ENG-SF21010-R1-FDR-Redlines.pdf Markup Summary

SF-21-010

**POND C4 EMERGENCY OVERFLOW AND CONCRETE CUTOFF WALL PROFILE**  
SCALE: NTS

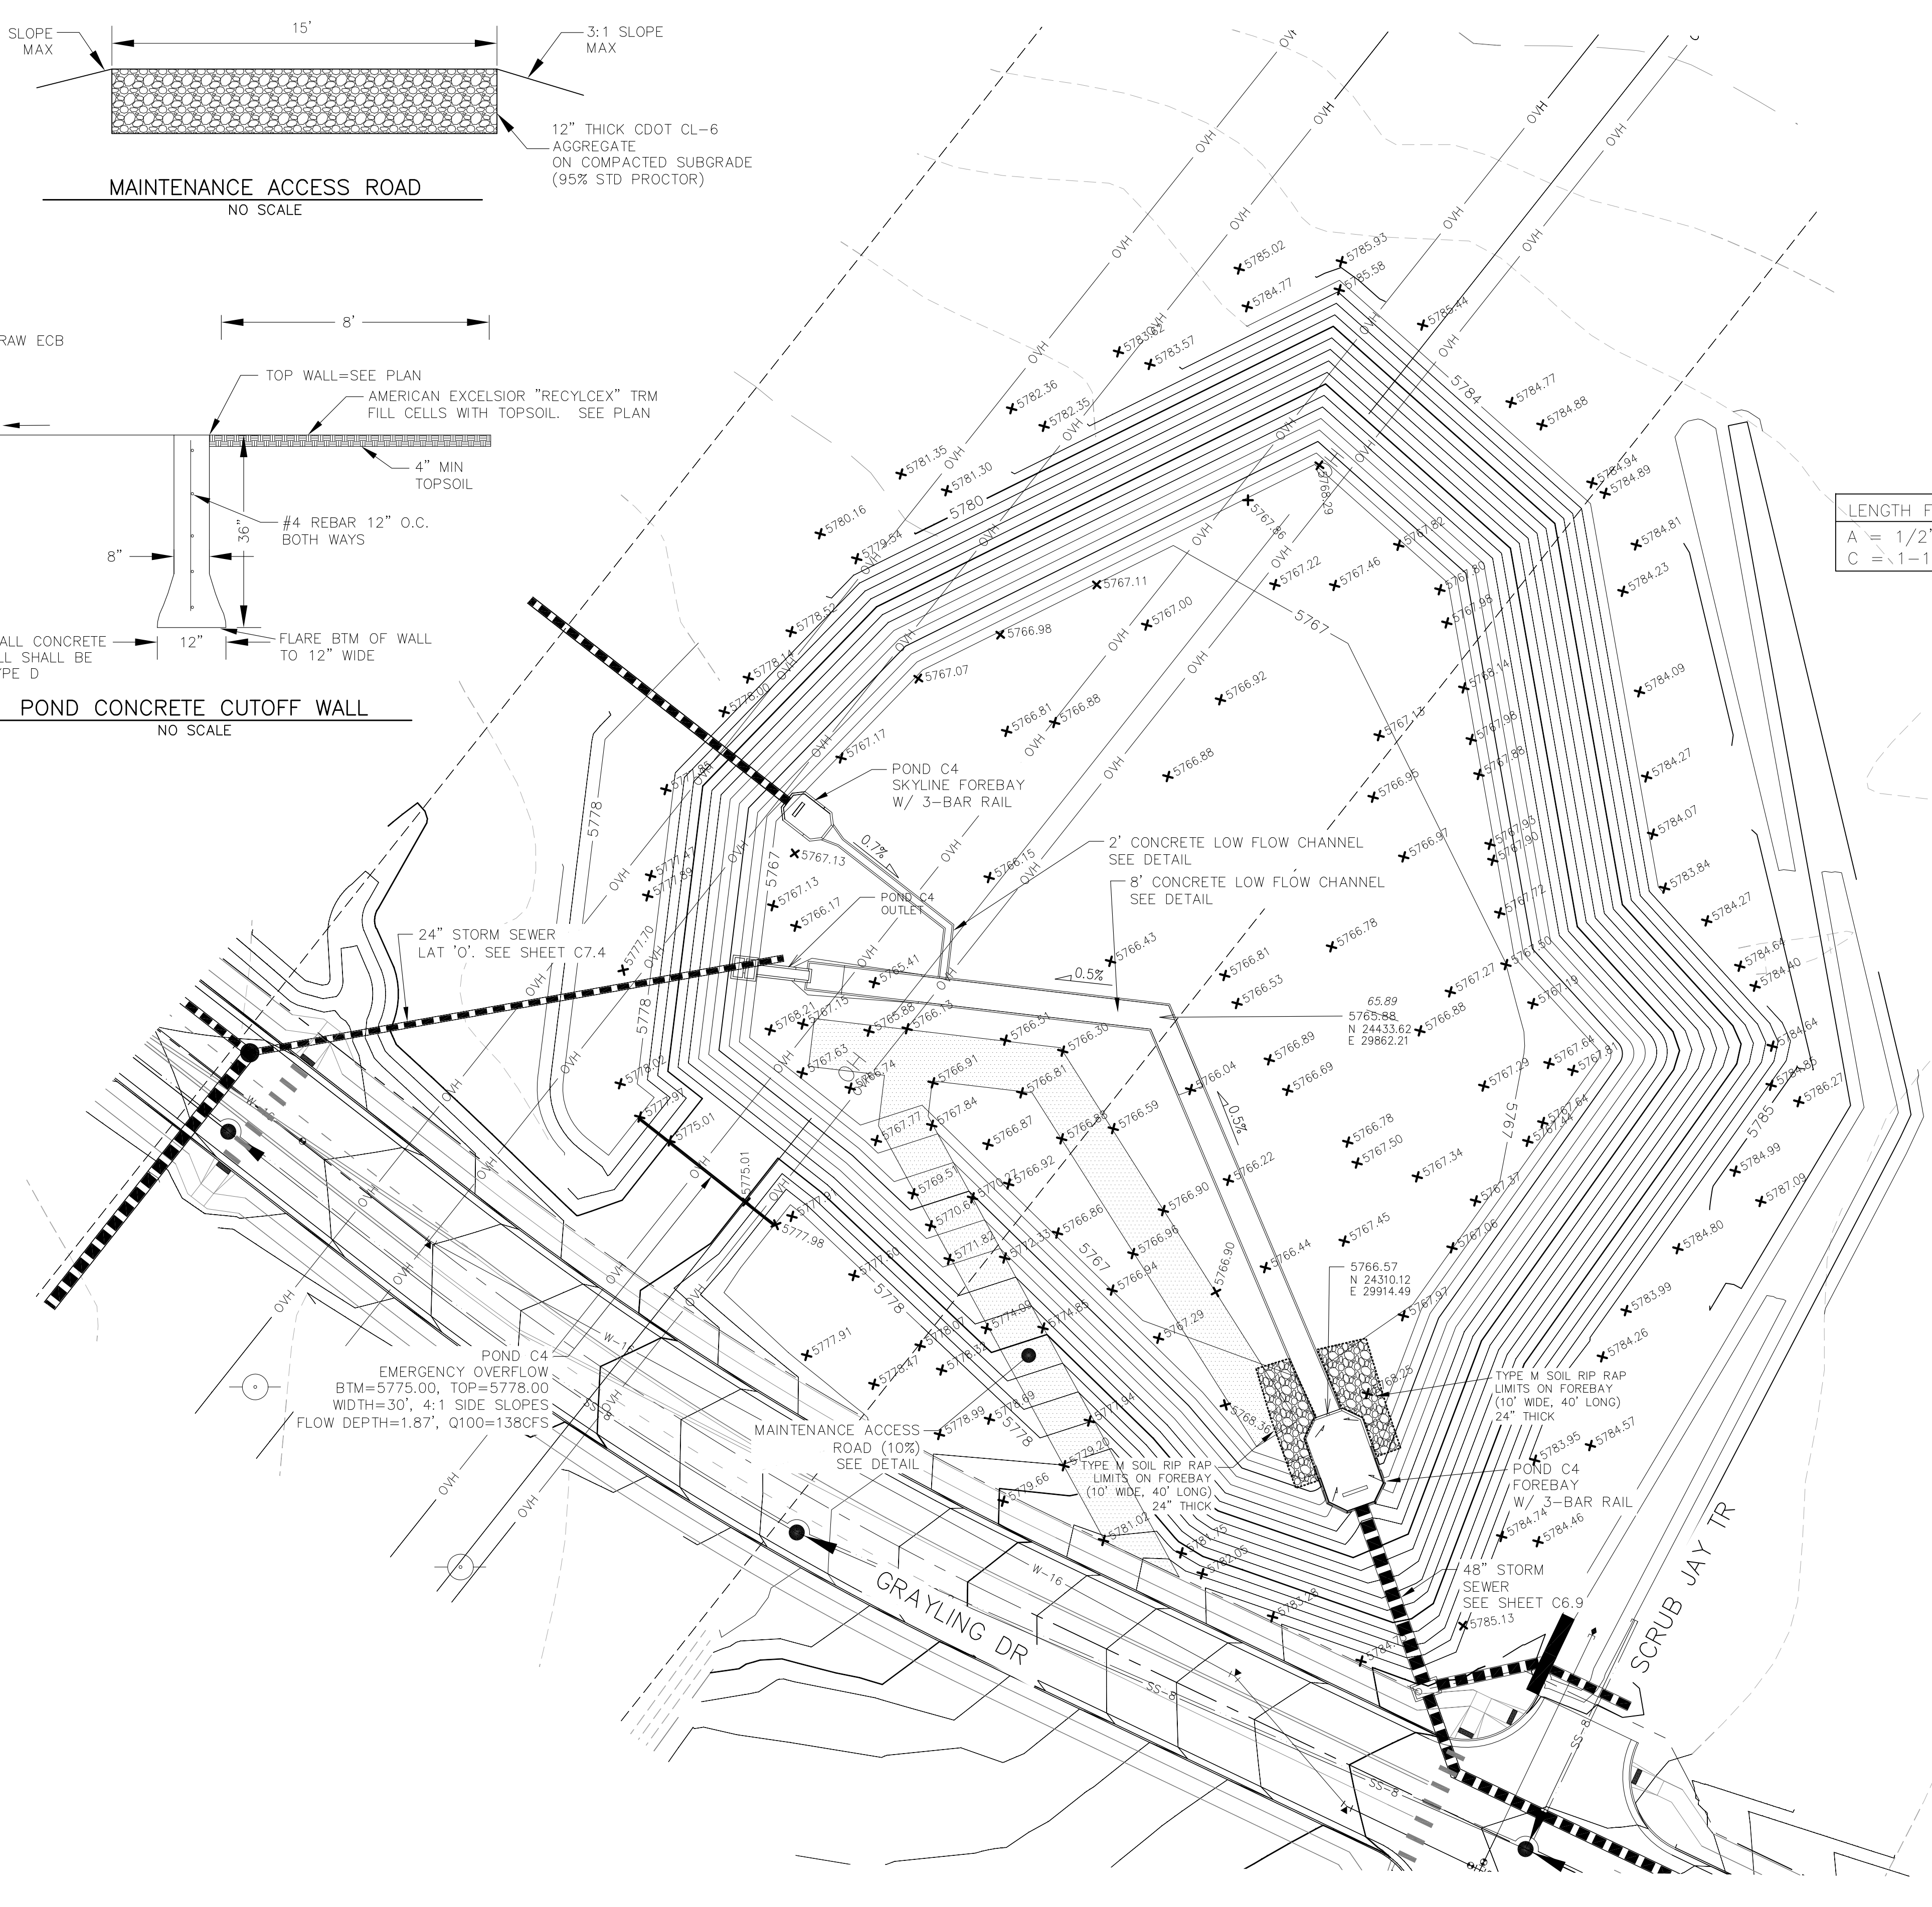
Show spillway
on plans

**POND C2.2 AND POND C2.3
 POND GRADING AND
 TRICKLE CHANNEL**

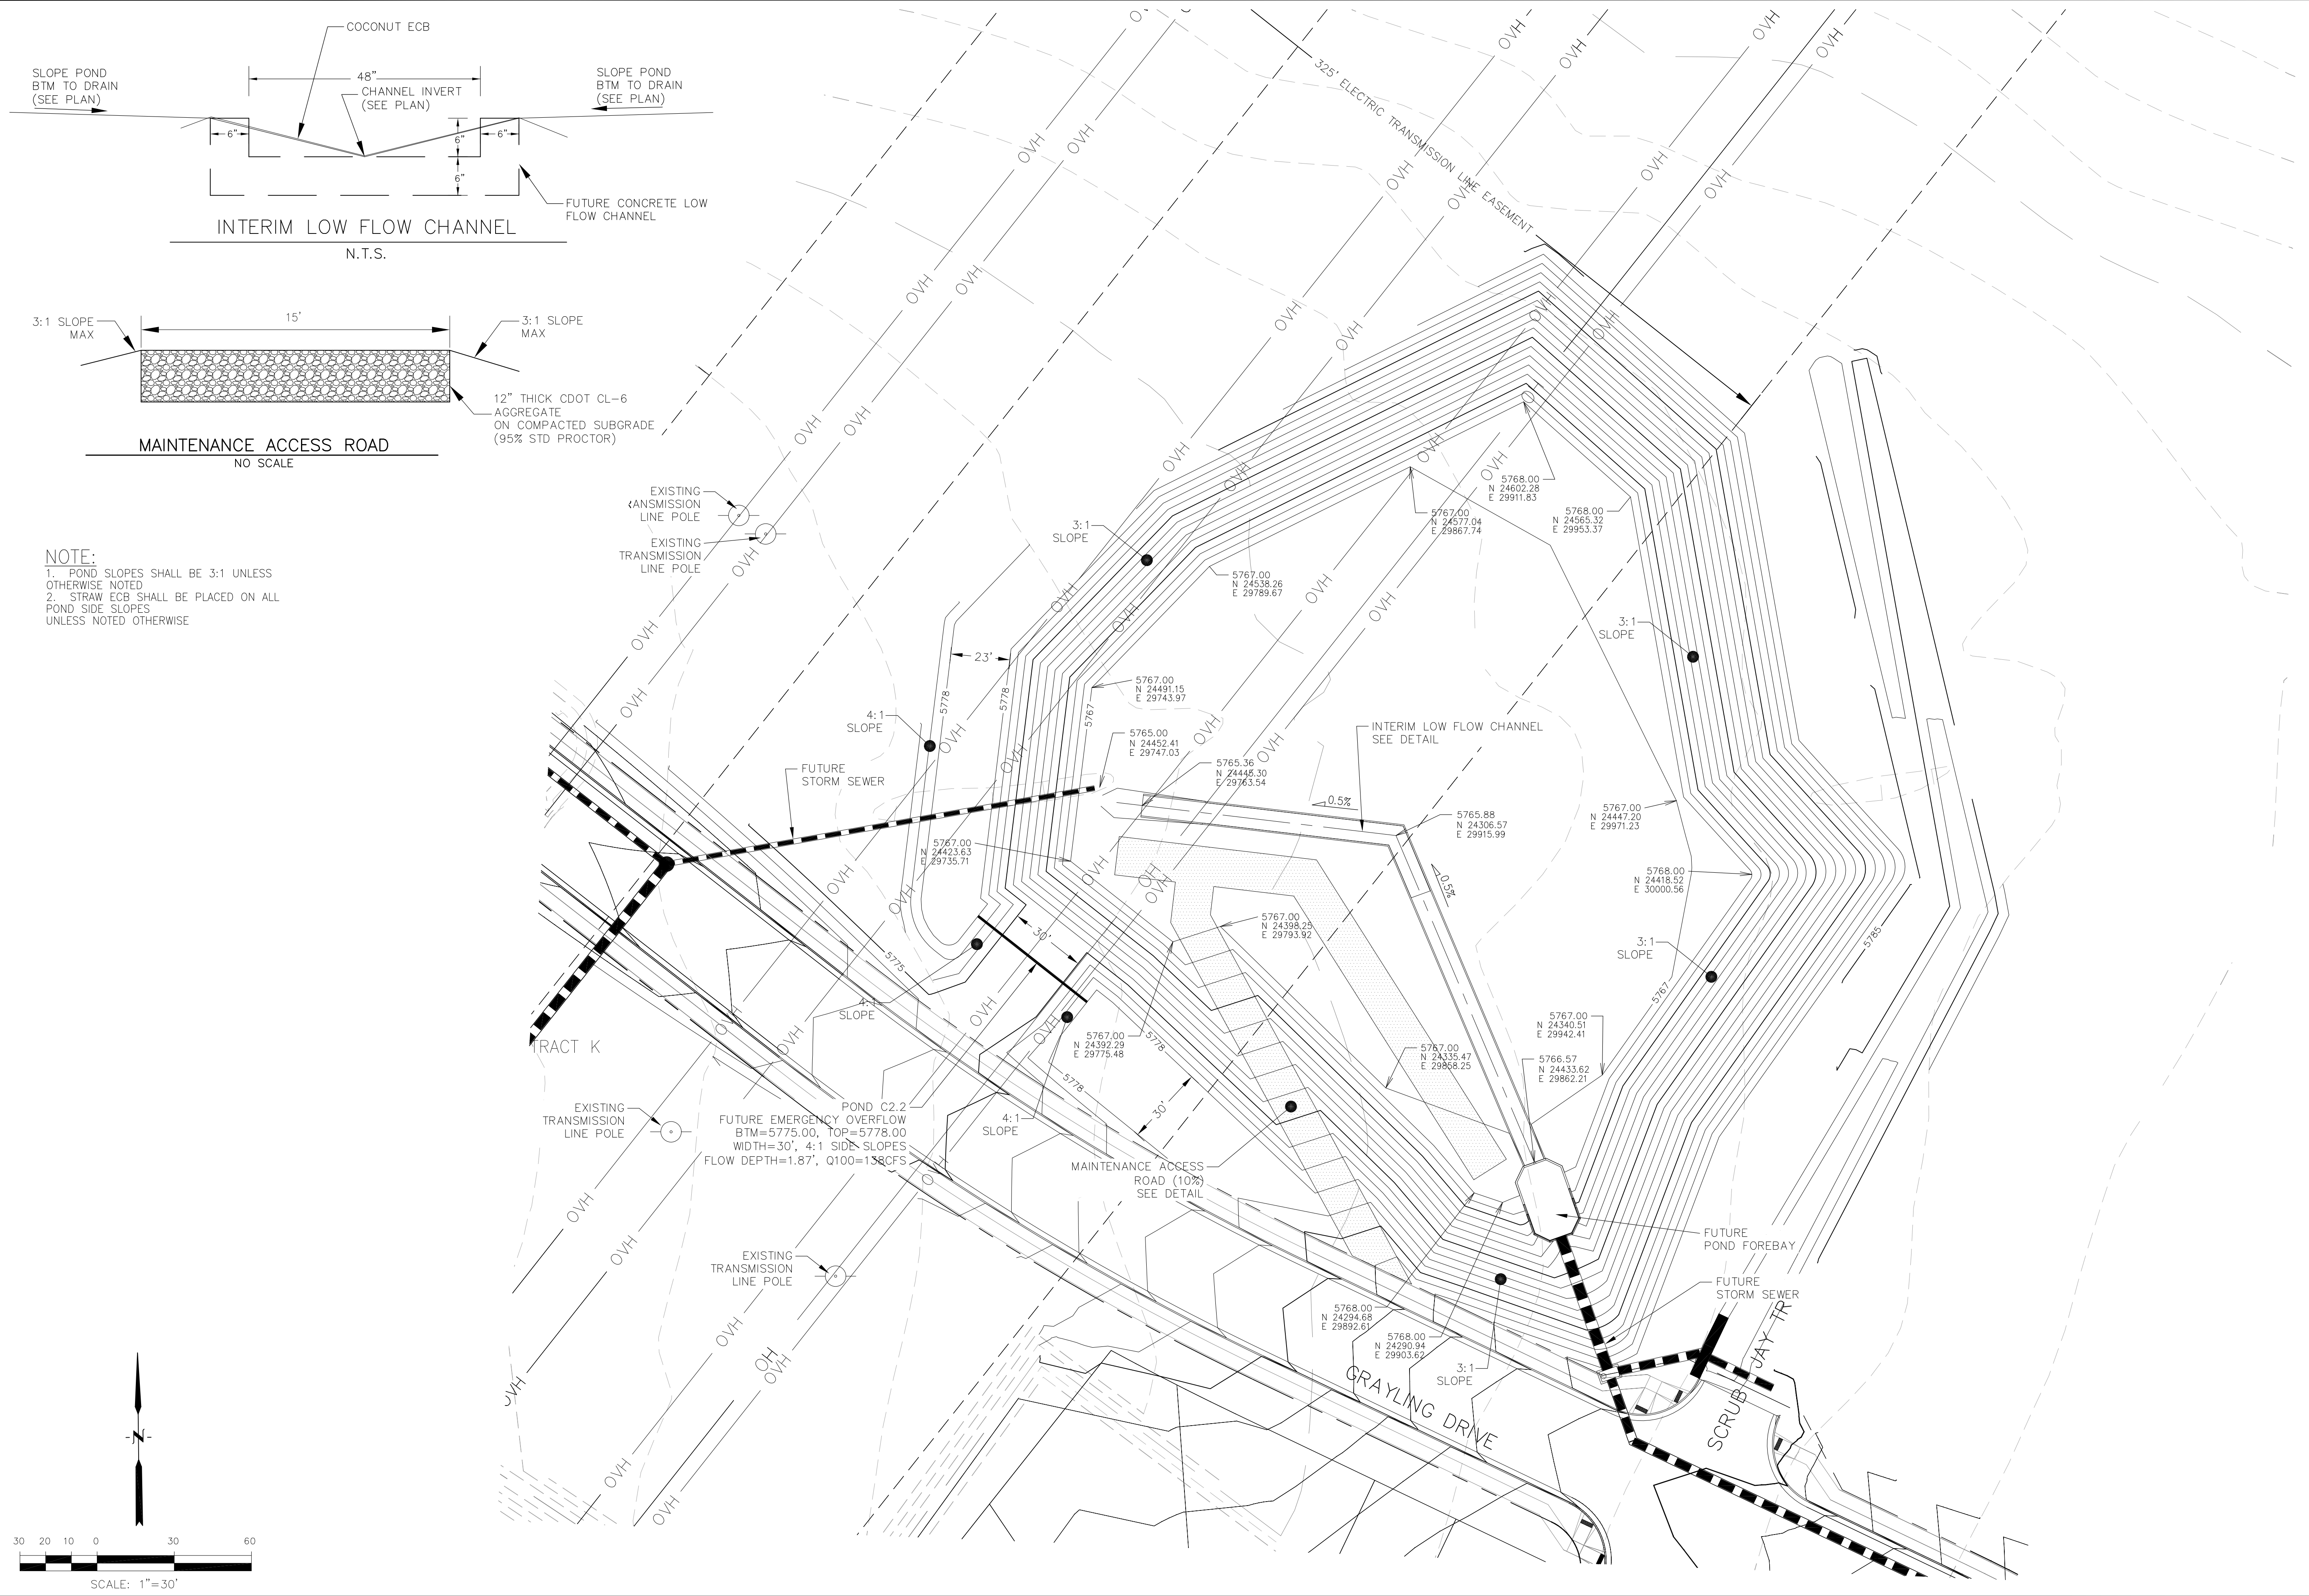
SWMP states that ponds C2.1 and C4 are existing. Reconcile the differences between the SWMP and FDR. Would also help to label these two ponds as "existing" in the GEC Plans and show existing in gray and proposed components in black.
